TO: Jeff Watson, Community Development Services  
FROM: Christina Wollman, Planner II *CW*  
DATE: October 18, 2010  
SUBJECT: Hanson BL-10-00037

The Public Works Department has reviewed the Request for Boundary Line Adjustment Application. In order to ensure that it meets current Kittitas County Road Standards, the applicant needs to provide the following prior to final approval:

Proposed

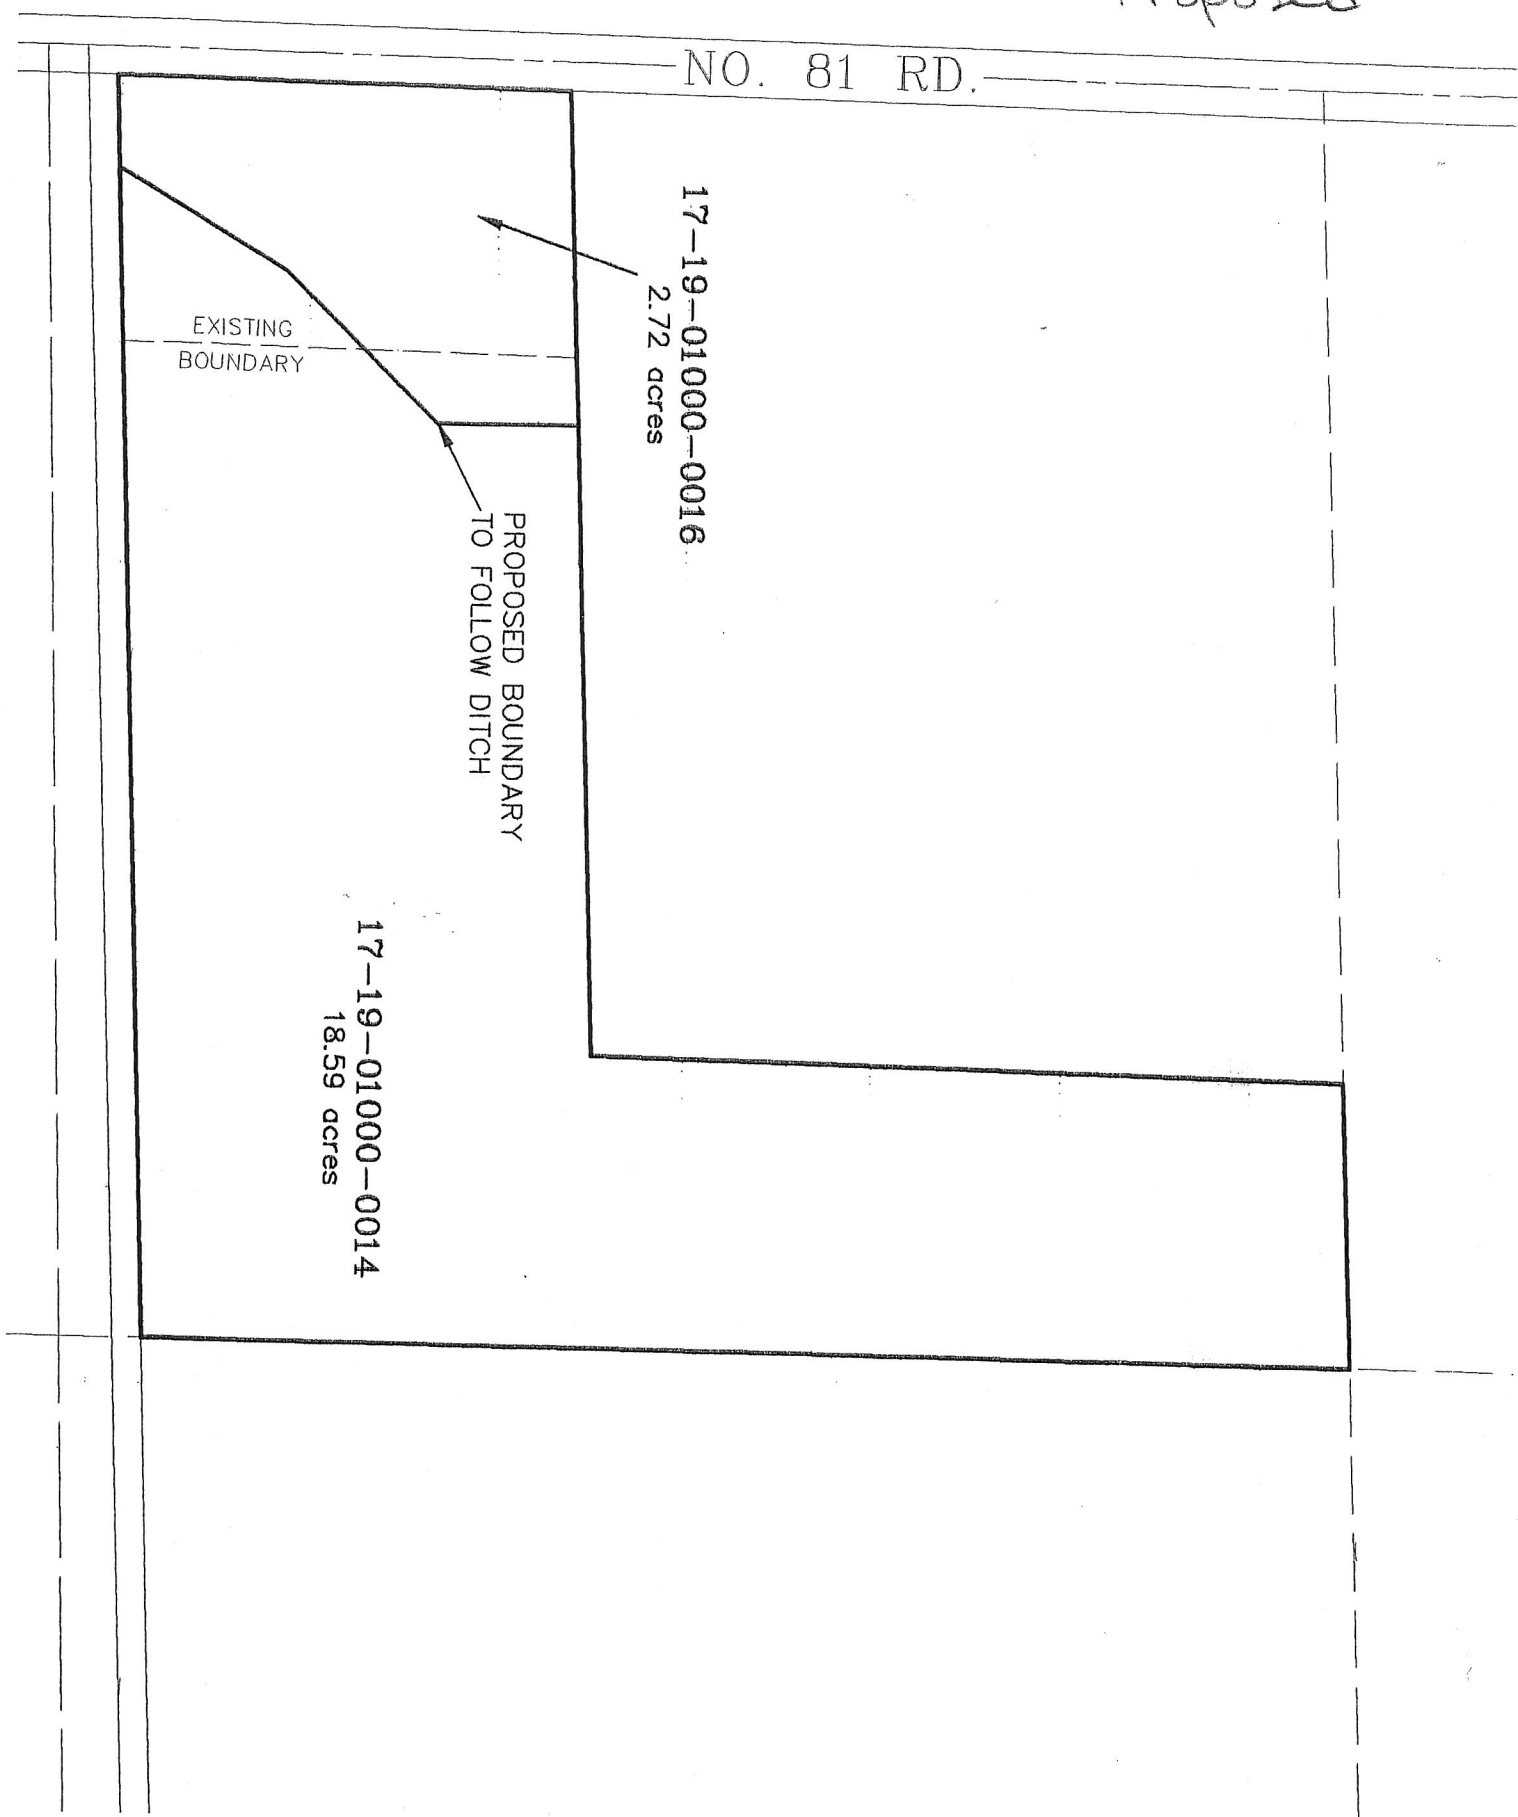
1. The proposed access with appropriate easement(s) shall be shown and shall conform to applicable Kittitas County Road Standards.
2. A revised legal description that describes the final configuration of the subject property shall be required.
